HONOR CHARTER SCHOOL
HONOR CHARTER SCHOOL BUILDING CORPORATION
8250 Bent Grass Meadows Drive, Peyton, Colorado 80831
Owner Project No. 3225193
AGENCY NUMBER: AHCA-123456.78

DATE OF ISSUE: 04.30.2026
PHASE: CONSTRUCTION DOCUMENTS
ISSUED FOR: CONSTRUCTION PERMIT
GRACE PROJECT NO: 3225193

V1_Lighting Plan.pdf Markup Summary

ELECTRICAL
SITE PLAN

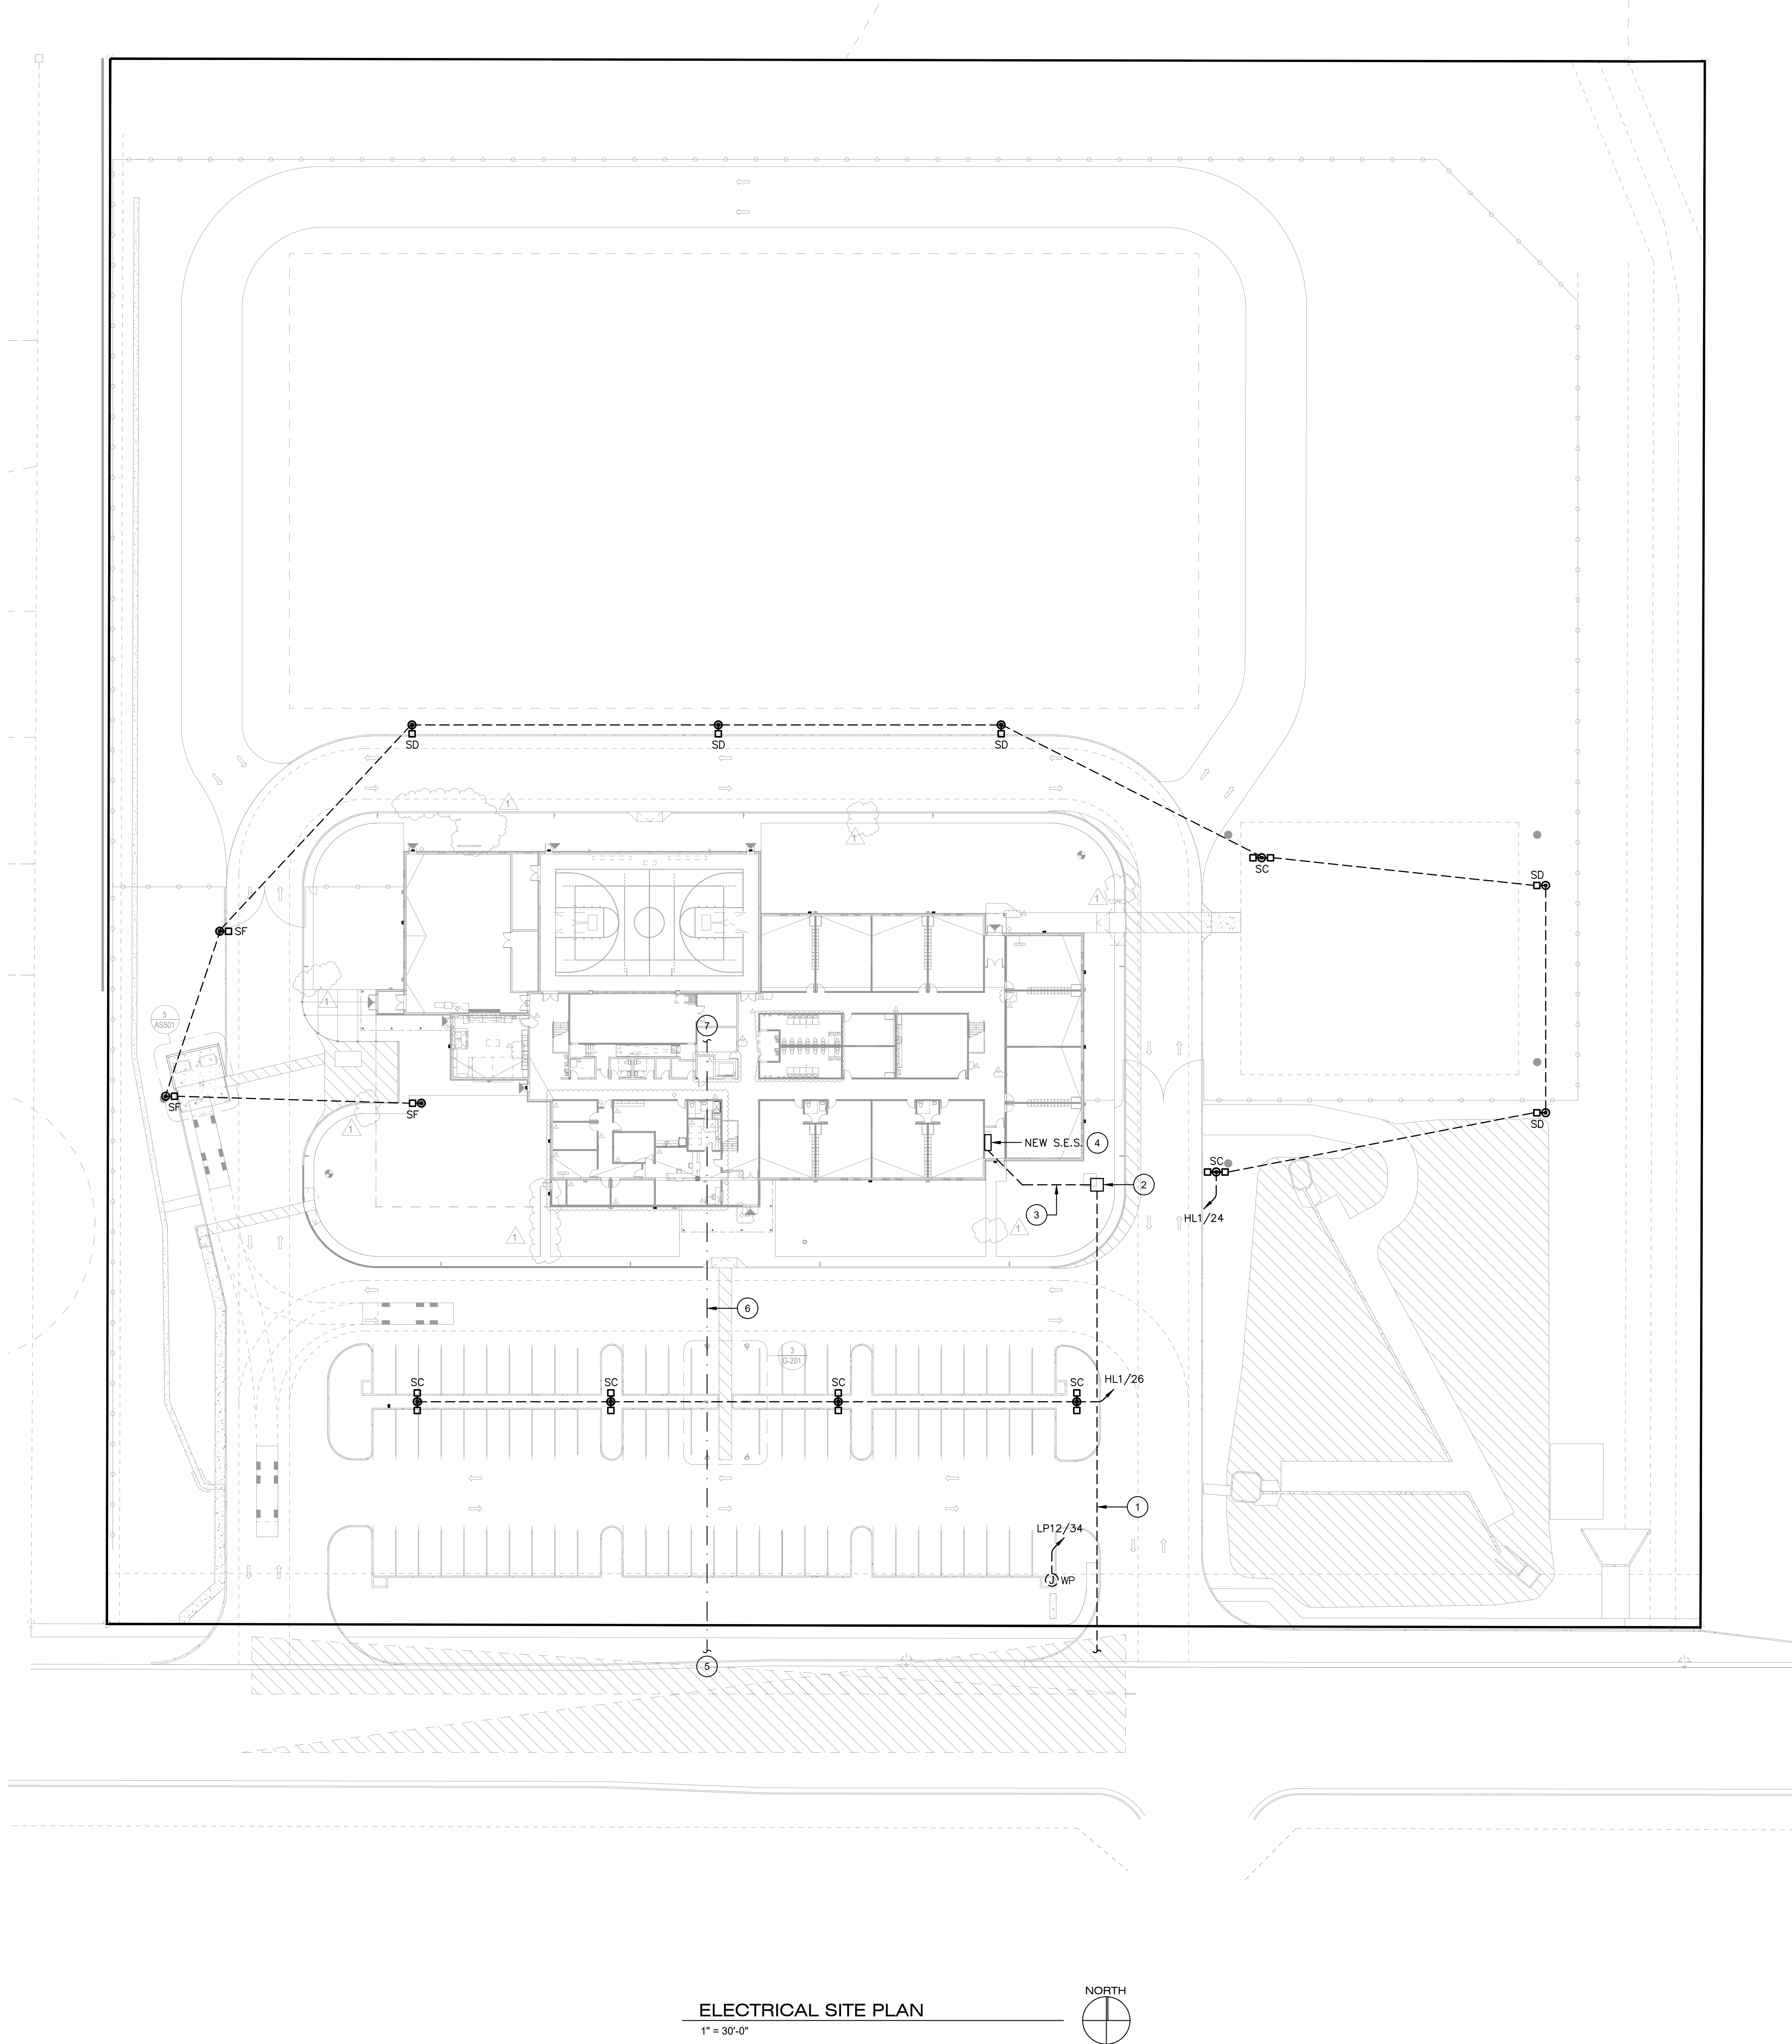
identify hours, height, cut off etc see Land
Development Code, section 6.2.3

(B)Design Standards and Requirements.

(1)Limitations on Extent of Lighted Area.

(a)Concealed or Shielded. Light fixtures shall be arranged and positioned such that the light sources are concealed and fully shielded so that no direct light or reflection creates a nuisance or hazard to any adjacent ownership or right-of-way and that up-light, spill-light, glare, and unnecessary diffusion are minimized. Light fixtures, except as otherwise permitted herein, are required to be full cutoff as defined by the Illuminating Engineers Society of North America (IESNA) The cut-off angle of an exterior light source shall not exceed 90 degrees. Full cut-off fixtures may not be tilted or aimed in a manner that results in light distribution above the horizontal plane. The use of semi-cutoff or cutoff (as opposed to full cutoff) fixtures shall be permitted to illuminate areas other than parking lots provided the pole or mounting point is no more than 10' in height and the maximum lumen output does not exceed 1800 lumens per lamp.(b)Non-Security Lighting During

Non-Operating Hours. Exterior lighting, including but not limited to floodlights used to light a building façade, shall be reduced, activated by motion sensor devices, or turned off during the principal use's non-operating hours. Lighting necessary for security shall not be subject to this

provision.(c)Upward Lighting. Upward lighting for architectural, landscape or decorative purposes shall have at least 90% of the total distribution pattern within the profile of the illuminated structure or feature. Light fixtures used to illuminate flags, statues, or any other objects mounted on a pole, pedestal, or platform, shall use a narrow cone of light that does not extend beyond the illuminated object.(d)Maximum Levels. Maximum on-site lighting levels shall not exceed 10 foot candles, except for loading and unloading platforms where the maximum lighting level shall be 20 foot candles.(e)Measurement at Property Boundaries.

Light levels measured at the property line of the development site adjacent to residential property or public right of way shall not exceed 0.1 foot candles as a direct result of the on-site lighting. All light fixtures mounted within 15' of any residential property line of the site shall be classified as IES Type II or Type III, or fixture demonstrated to provide similar distribution patterns and shielding properties. Fixtures shall be fitted with "house side shield" reflectors on the sides facing the residential property line.(f)Light Standards and Fixtures. The style of light standards and fixtures shall be consistent with the style and character of architecture proposed on the site. Poles shall be anodized or coated to minimize glare from the light source. Bollards or similar light fixtures intended to illuminate landscape features or walkways are permitted which do not exceed 4 feet in height, 2 fixtures per bollard and 1 lamp not exceeding 900 lumens per fixture.(g)Lamp Types. All outdoor light fixtures should utilize 1 of the following lamp types: metal halide, induction lamp, compact fluorescent, incandescent (including tungsten-halogen), or high-pressure sodium. Alternatives are permitted provided they are demonstrated to be more effective for the proposed use based on IESNA recommendations.(h)Canopy Lighting. Light fixtures associated with canopies, including but not limited to fuel islands, seasonal outdoor sales areas, shopping malls, theaters, bank drive-thrus,

ES-112

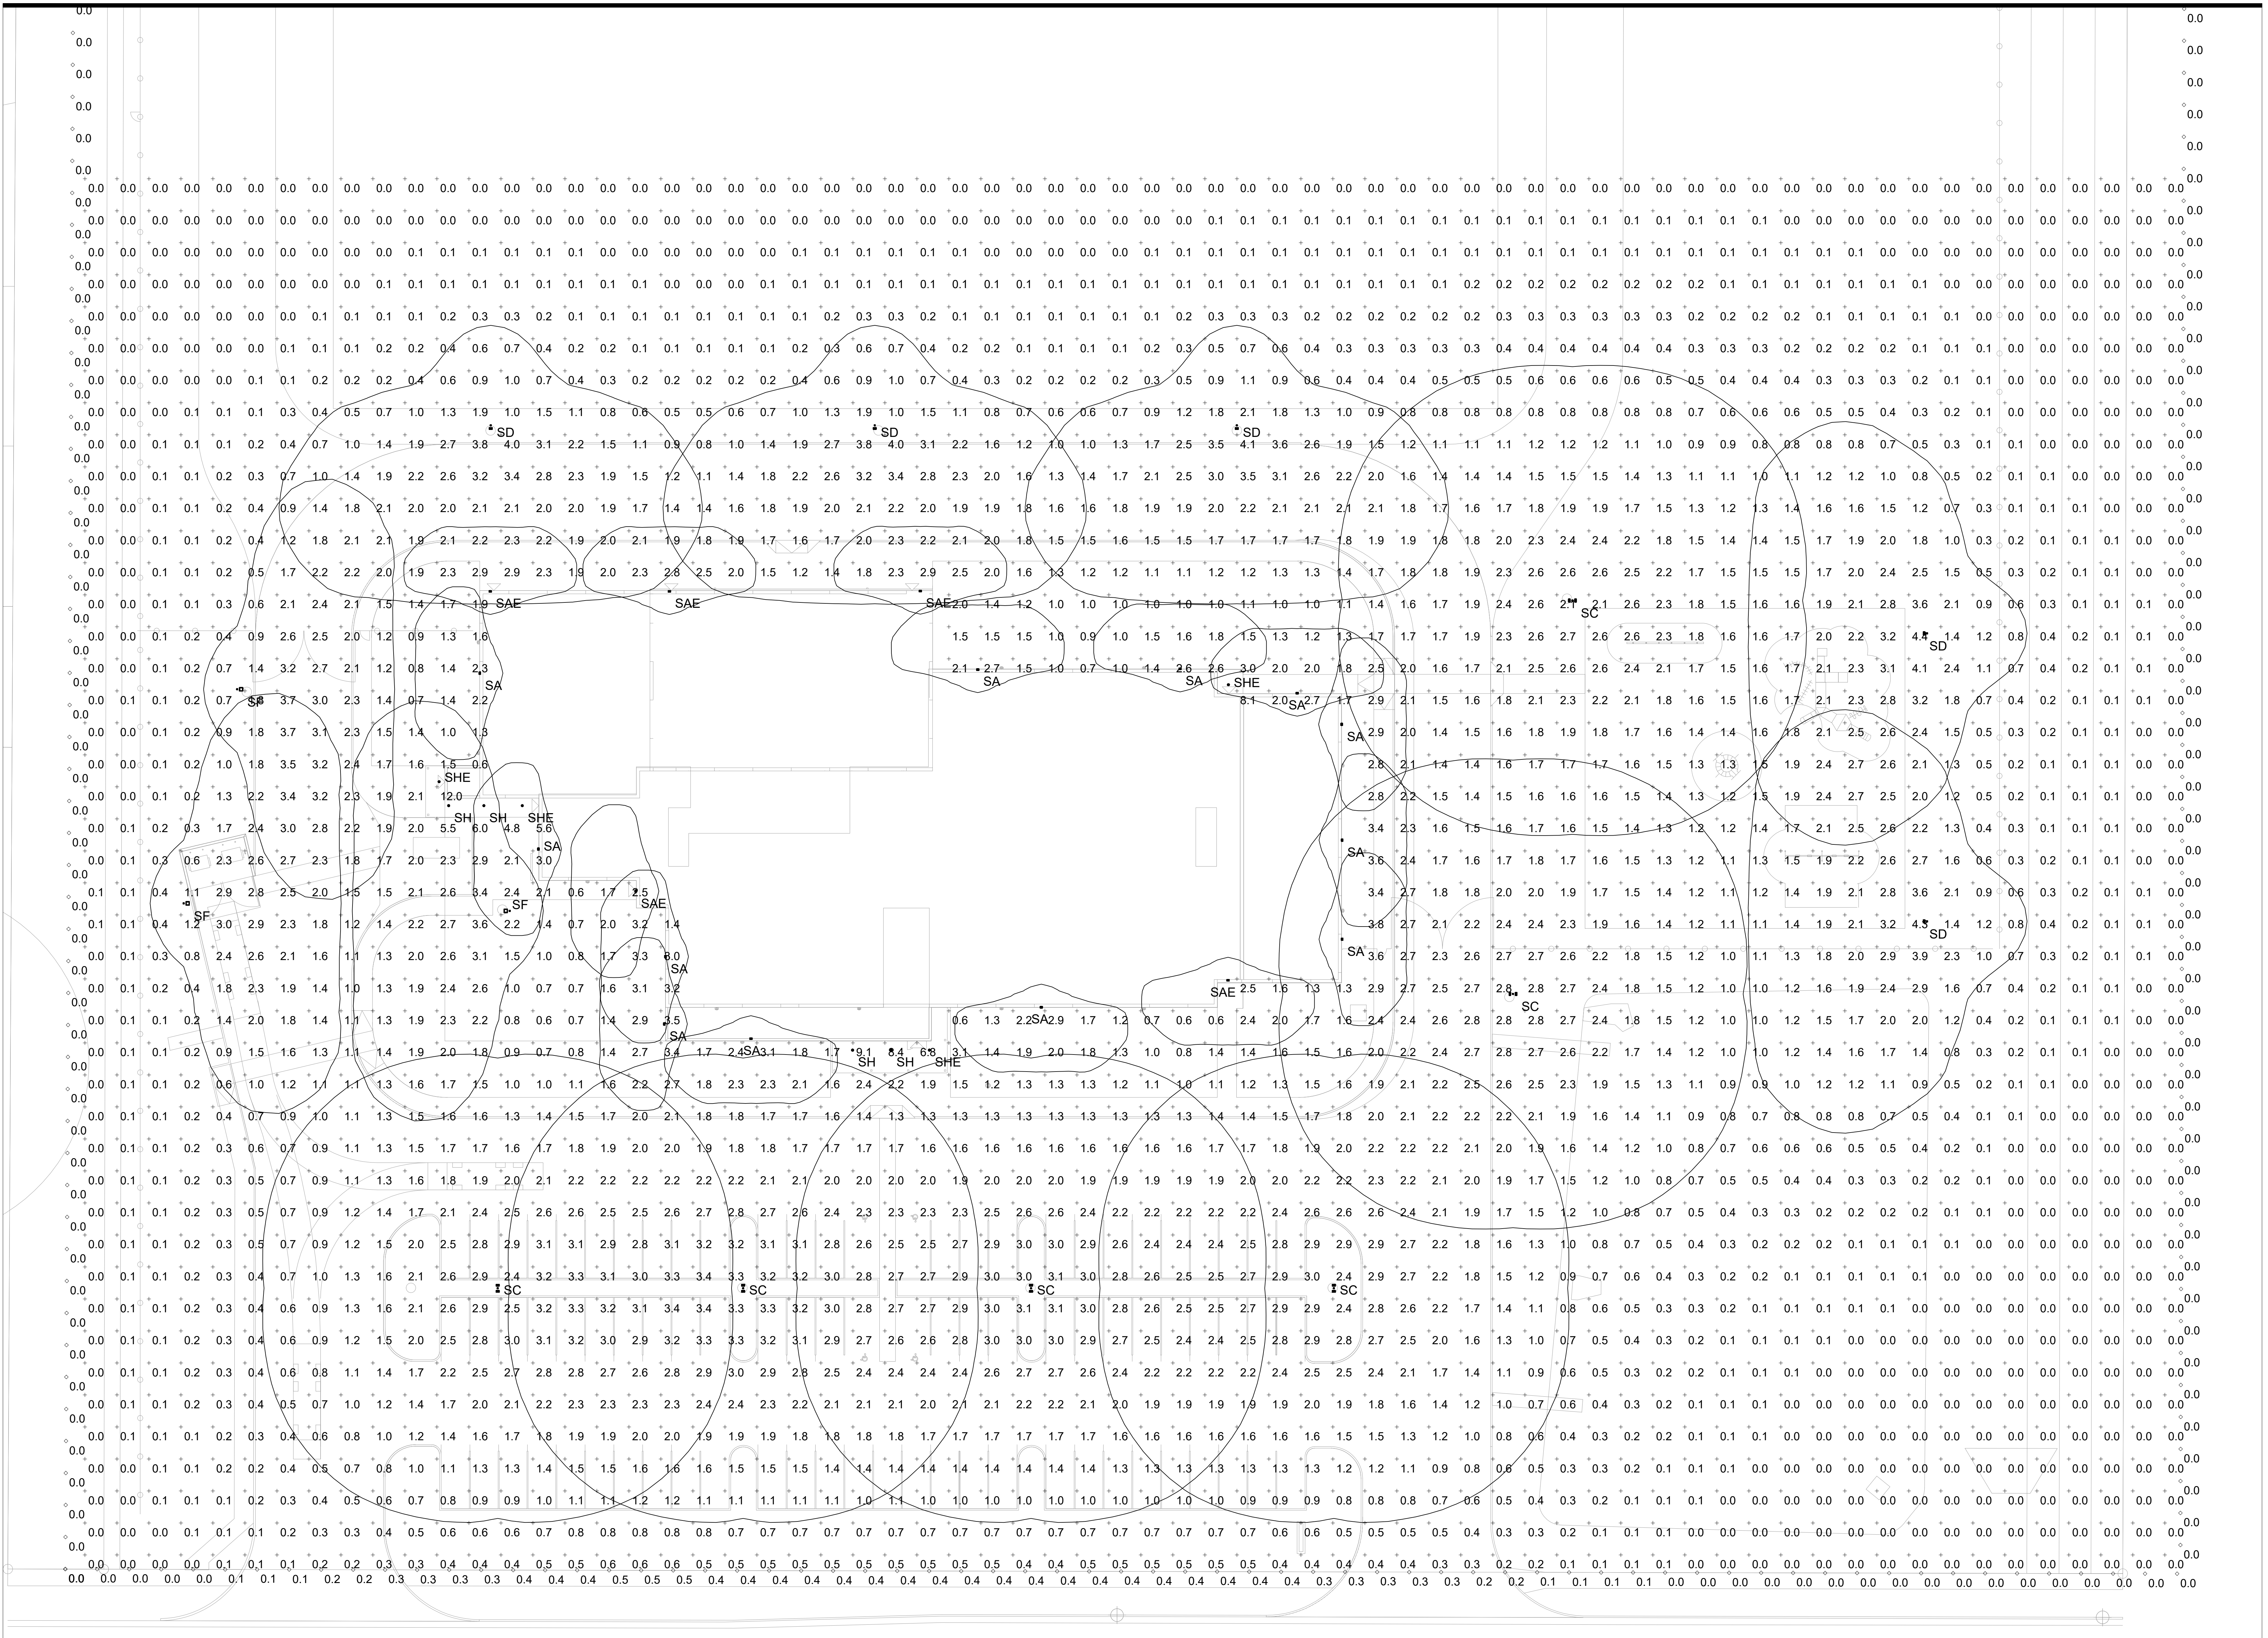
Add property lines and verify full cut off fixtures and provide height of pole mounts. Please see lighting standards in Code

(B)Design Standards and Requirements.

(1)Limitations on Extent of Lighted Area.

(a)Concealed or Shielded. Light fixtures shall be arranged and positioned such that the light sources are concealed and fully shielded so that no direct light or reflection creates a nuisance or hazard to any adjacent ownership or right-of-way and that up-light, spill-light, glare, and unnecessary diffusion are minimized. Light fixtures, except as otherwise permitted herein, are required to be full cutoff as defined by the Illuminating Engineers Society of North America (IESNA) The cut-off angle of an exterior light source shall not exceed 90 degrees. Full cut-off fixtures may not be tilted or aimed in a manner that results in light distribution above the horizontal plane. The use of semi-cutoff or cutoff (as opposed to full cutoff) fixtures shall be permitted to illuminate areas other than parking lots provided the pole or mounting point is no more than 10' in height and the maximum lumen output does not exceed 1800 lumens per lamp.(b)Non-Security Lighting During

Non-Operating Hours. Exterior lighting, including but not limited to floodlights used to light a building façade, shall be reduced, activated by motion sensor devices, or turned off during the principal use's non-operating hours. Lighting necessary for security shall not be subject to this

provision.(c)Upward Lighting. Upward lighting for architectural, landscape or decorative purposes shall have at least 90% of the total distribution pattern within the profile of the illuminated structure or feature. Light fixtures used to illuminate flags, statues, or any other objects mounted on a pole, pedestal, or platform, shall use a narrow cone of light that does not extend beyond the illuminated object.(d)Maximum Levels. Maximum on-site lighting levels shall not exceed 10 foot candles, except for loading and unloading platforms where the maximum lighting level shall be 20 foot candles.(e)Measurement at Property Boundaries.

Light levels measured at the property line of the development site adjacent to residential property or public right of way shall not exceed 0.1 foot candles as a direct result of the on-site lighting. All light fixtures mounted within 15' of any residential property line of the site shall be classified as IES Type II or Type III, or fixture demonstrated to provide similar distribution patterns and shielding properties. Fixtures shall be fitted with "house side shield" reflectors on the sides facing the residential property line.(f)Light Standards and Fixtures. The style of light standards and fixtures shall be consistent with the style and character of

architecture proposed on the site. Poles shall be anodized or coated to minimize glare from the light source. Bollards or similar light fixtures intended to illuminate landscape features or walkways are permitted which do not exceed 4 feet in height, 2 fixtures per bollard and 1 lamp not exceeding 900 lumens per fixture.(g)Lamp Types. All outdoor light fixtures should utilize 1 of the following lamp types: metal halide, induction lamp, compact fluorescent, incandescent (including tungsten-halogen), or high-pressure sodium. Alternatives are permitted provided they are demonstrated to be more effective for the proposed use based on IESNA recommendations.(h)Canopy Lighting. Light fixtures associated with canopies, including but not limited to fuel islands, seasonal outdoor sales areas, shopping malls, theaters, bank drive-thrus,

is this sign electric and does it change messages?
 provide lumens at property lines
